Project# 1010581

16DRB-70023 EPC APPROVED SDP FOR BUILD PERMIT

DATE: January 22, 2016
TO: Jack Cloud, DRB Chair
FROM: Catalina Lehner, Senior Planner *CLL*
RE: Project #1010581, Tramway Taproom
Zone Change and As-Built Site Development Plan for Building Permit

Re: **Existing Canyon Plaza Development at: 417 Tramway Boulevard NE
Zone Map Amendment and Site Development Plan for Building Permit
Project Number #1010581
EPC Number # 15EPC-40045 and 15EPC-40046**

Existing Site Conditions-Site Development Plan for Building Permit

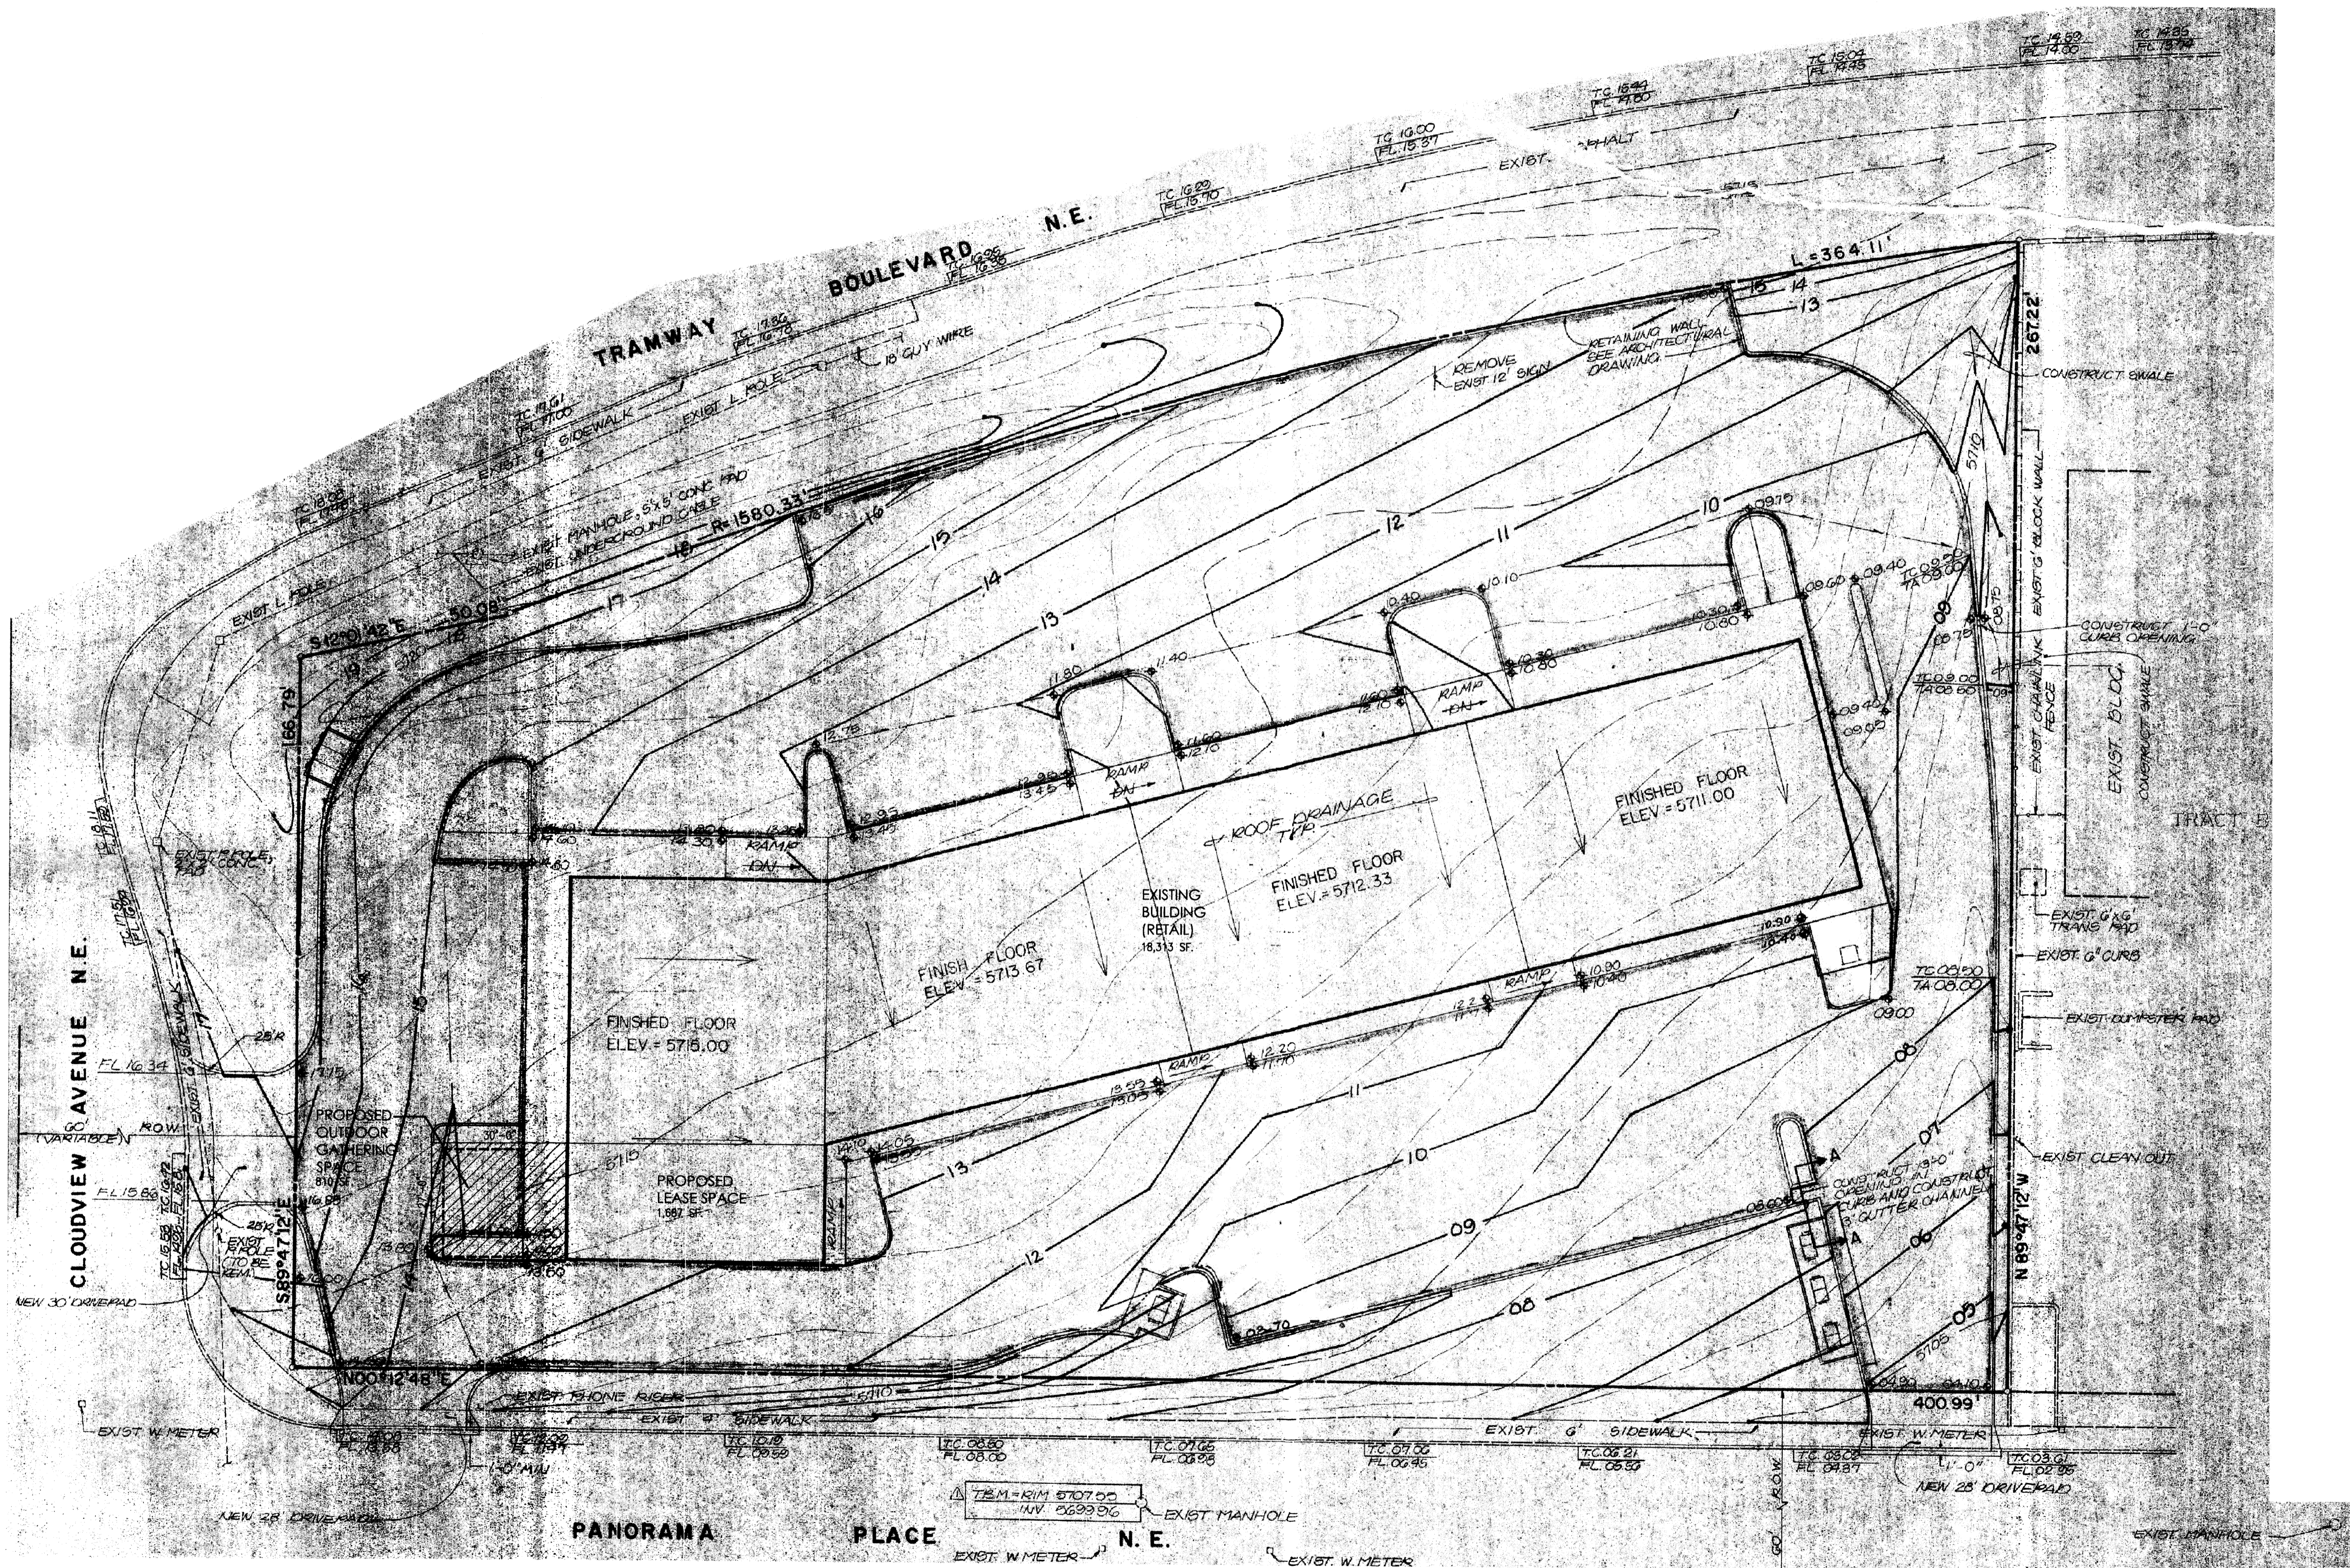
5. Clarification: Remove the reference to "sector development plan" from Sheet 1. The reference to the "sector development plan" was removed from note label "D" under "Site Development General Notes".

6. Utilities: Information regarding any existing easements shall be provided and/or clarified on Sheet 1.

The following note was added to the Site Development Plan for Building Permit site plan under "Site Development General Notes" letter "E": "ALL UTILITIES SHOWN ARE EXISTING TO REMAIN ALONG WITH ASSOCIATED EASEMENTS WITHIN THE EXISTING RECORDED PLAT."

Existing Site Conditions-Landscaping Plan

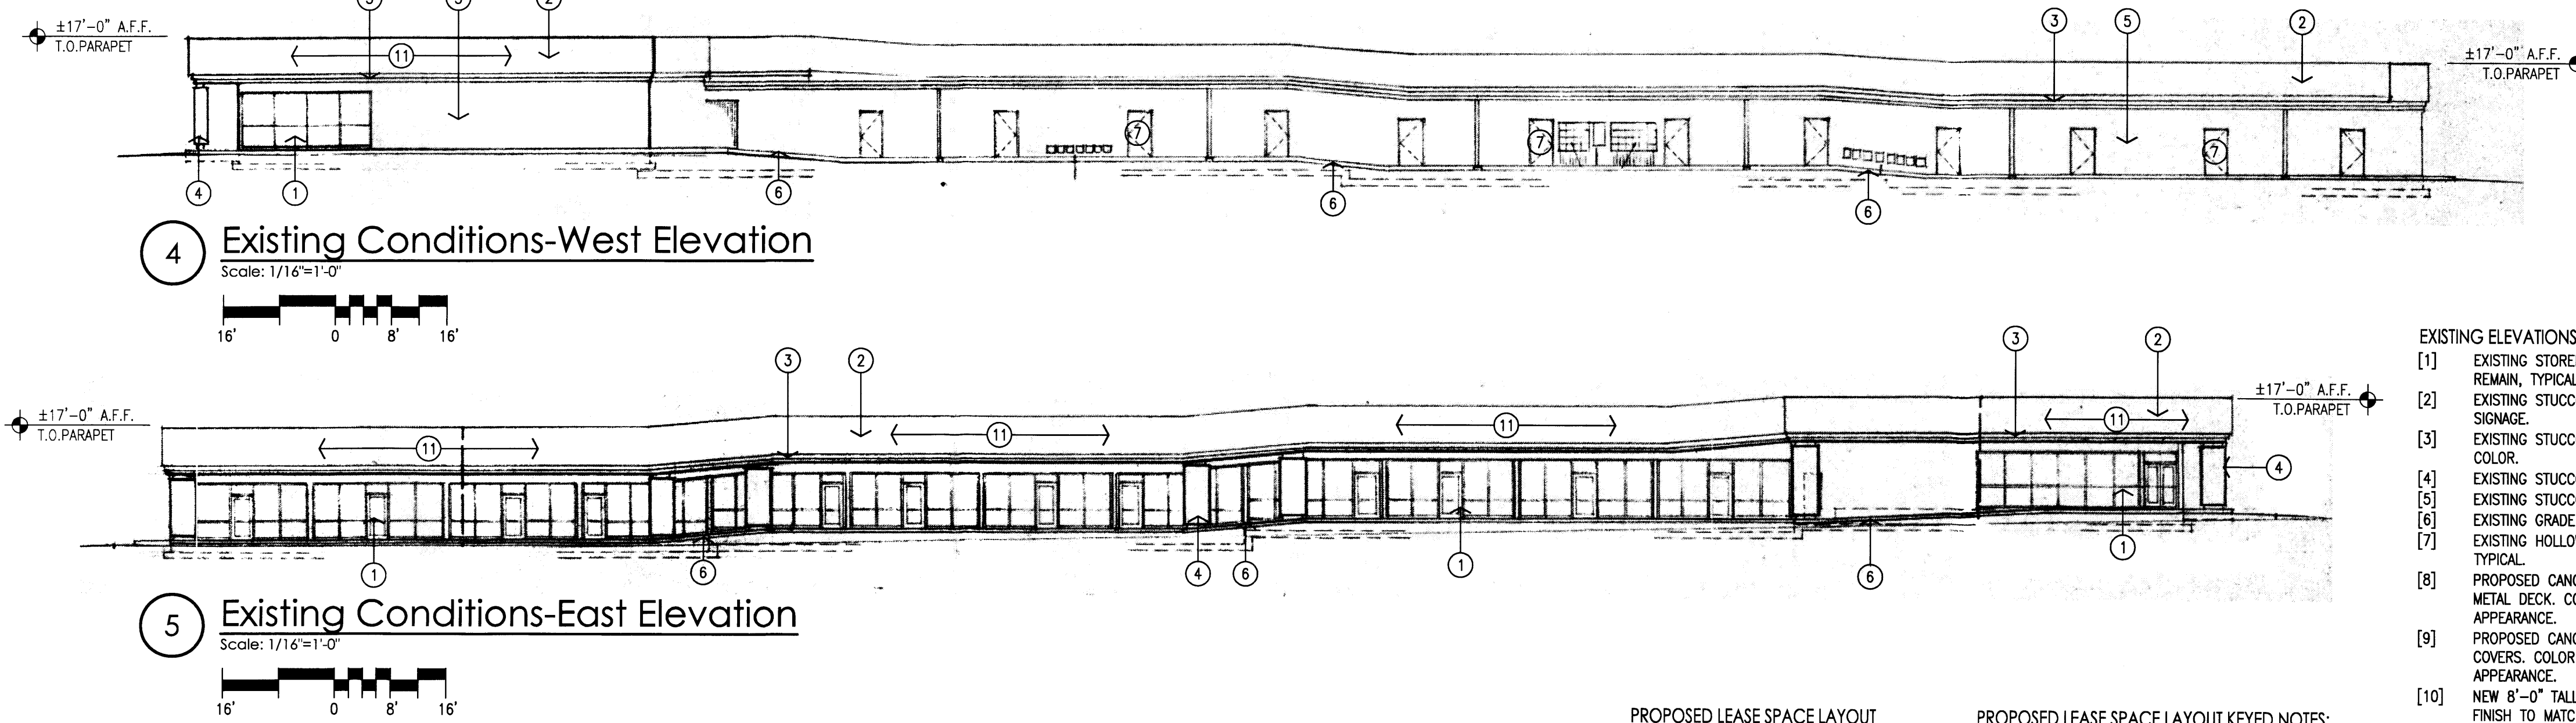
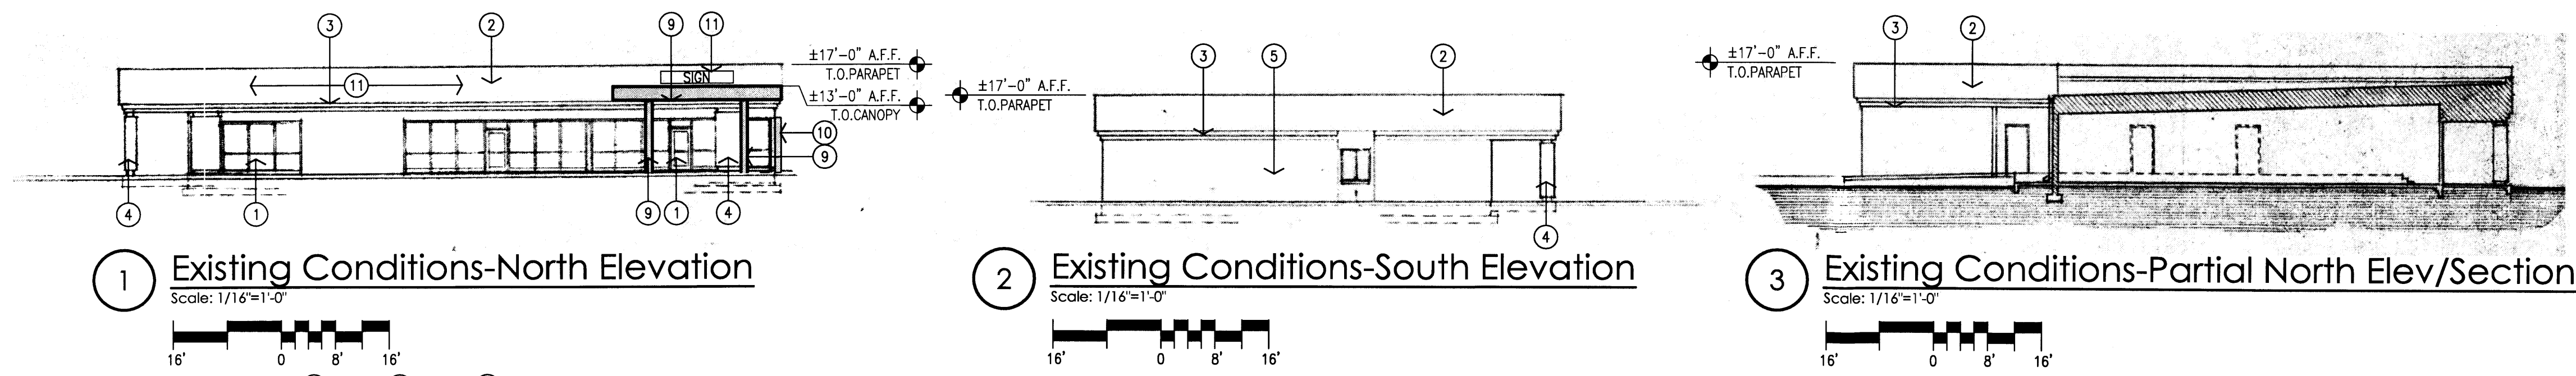
3. *Landscaping: A legend shall be added to indicate tree and plant types.*
A legend showing the existing trees and plants has been added to the existing landscaping plan.

7 Existing Pylon and Monument Sign Along Tramway Blvd.
Scale: Not to Scale

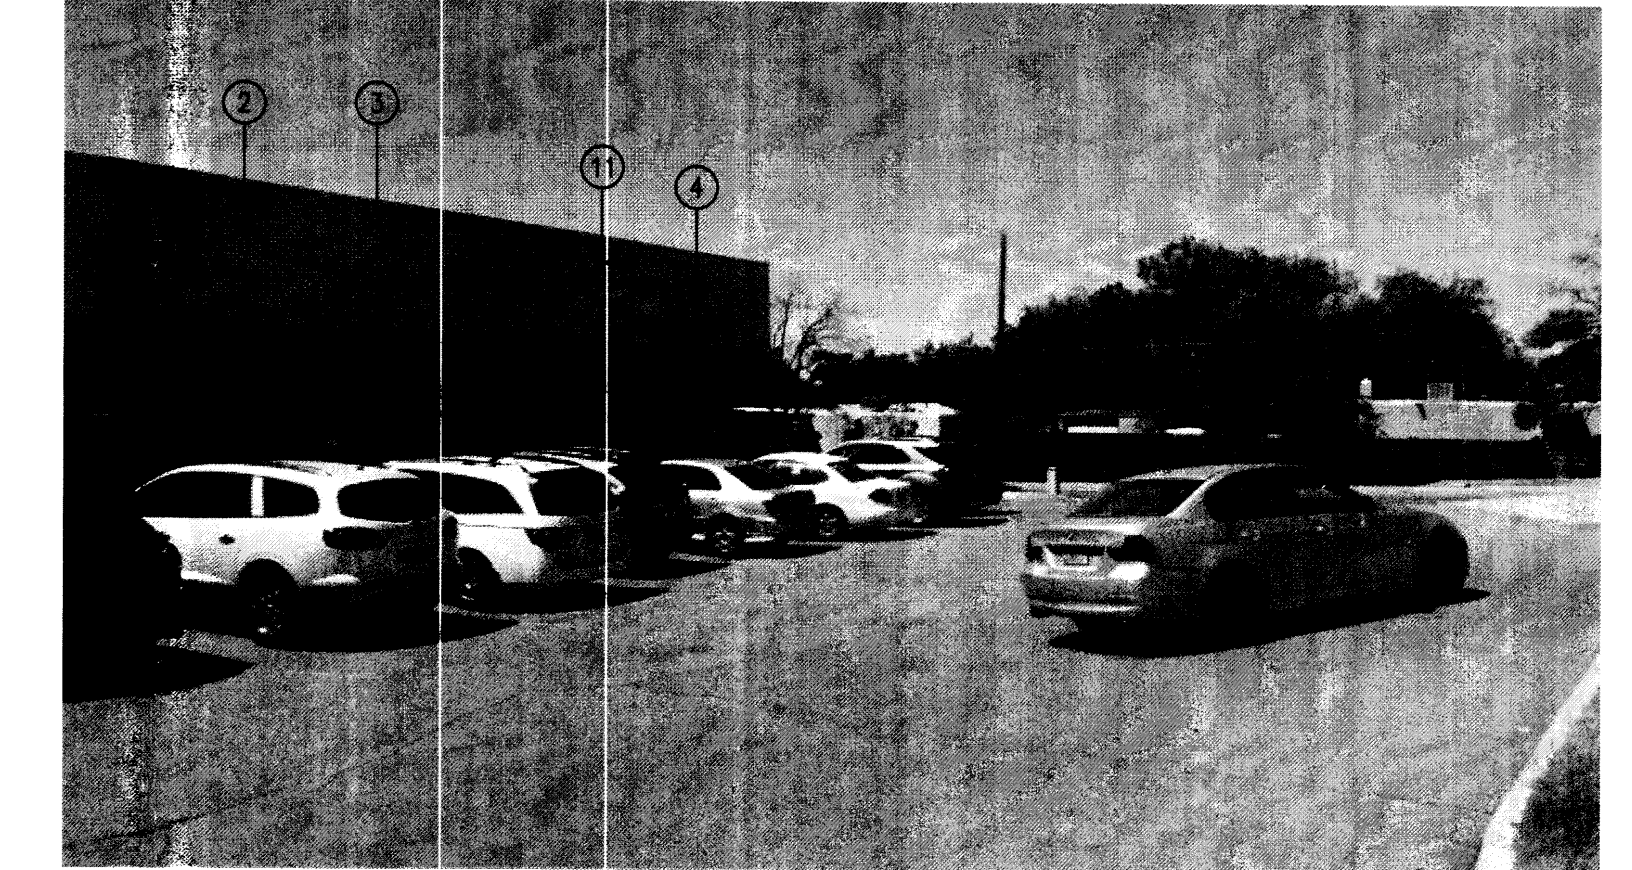
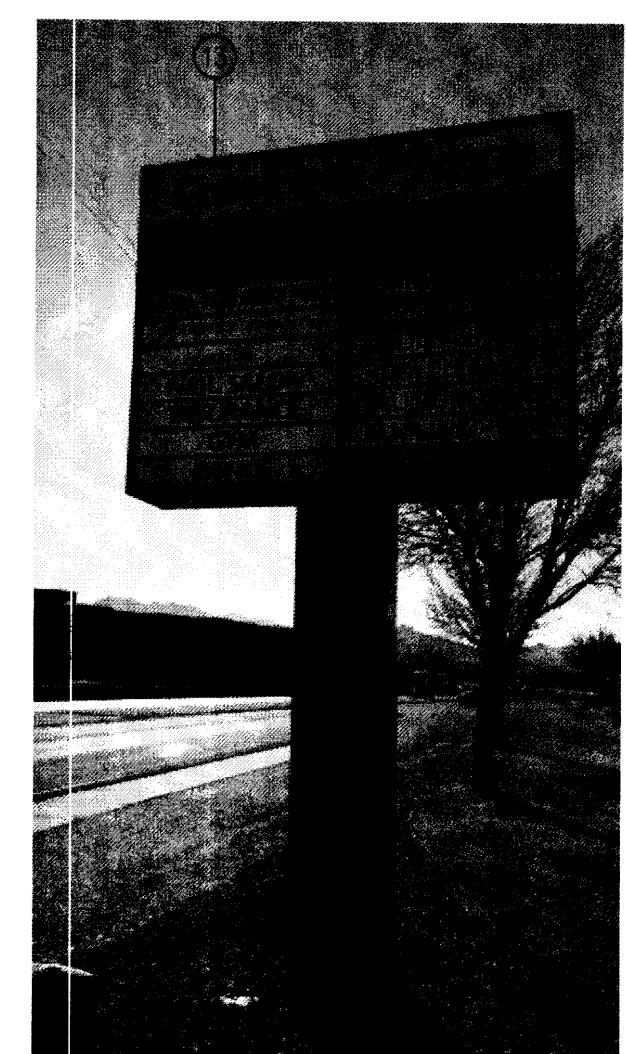
4. *Signage:*
 - A. *A sign detail that specifies color(s), material(s), and illumination of the existing pylon sign and monument sign shall be provided.*

Photos were added of the existing pylon, monument and building mounted signage. Refer to page 1 of 4. General Note "D" also enforces that "ALL SIGNAGE IS UNDER SPERATE PERMIT AS DIDICATED BY THE ZONING CODE".

12 Existing Typical Handicap Parking Spaces
Scale: Not to Scale

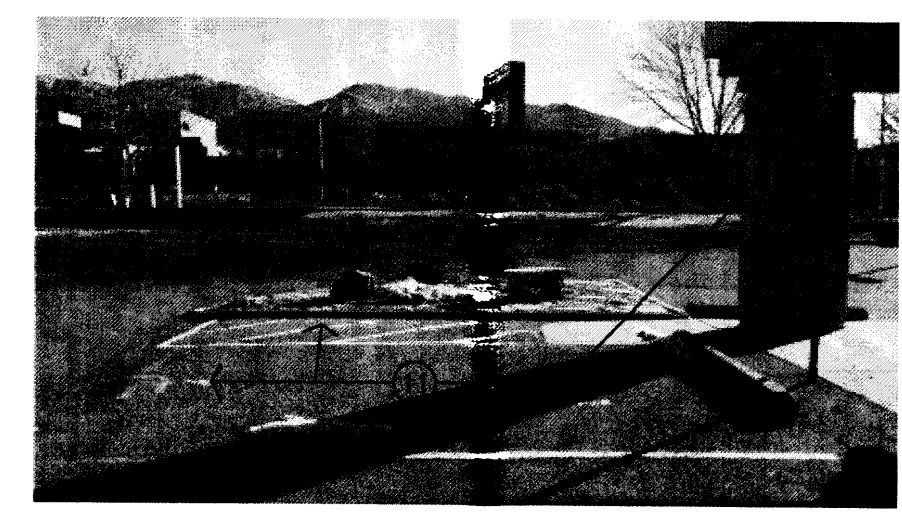
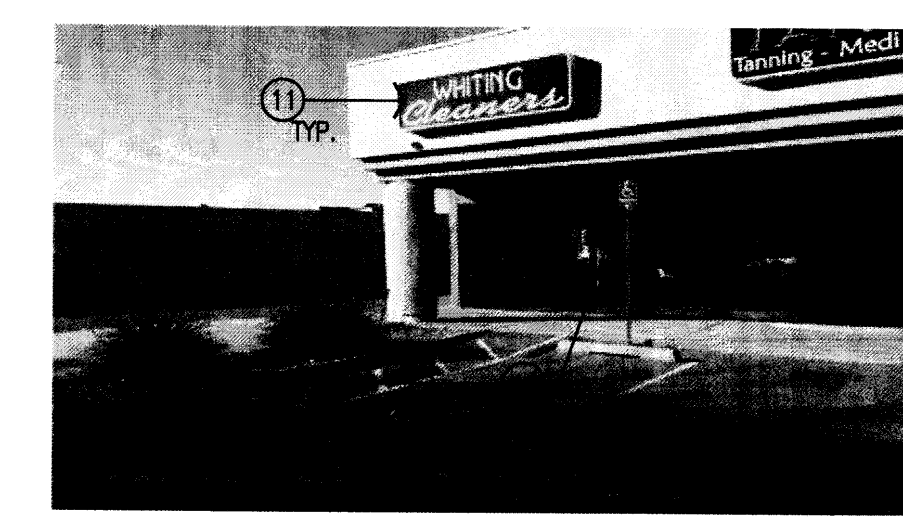
9. Condition from Transportation Development: The site shall be revised to meet current ADA requirements at the DRB.

Photos were added depicting the existing ADA site requirements for parking. Refer to page 1 & 4 of 4.
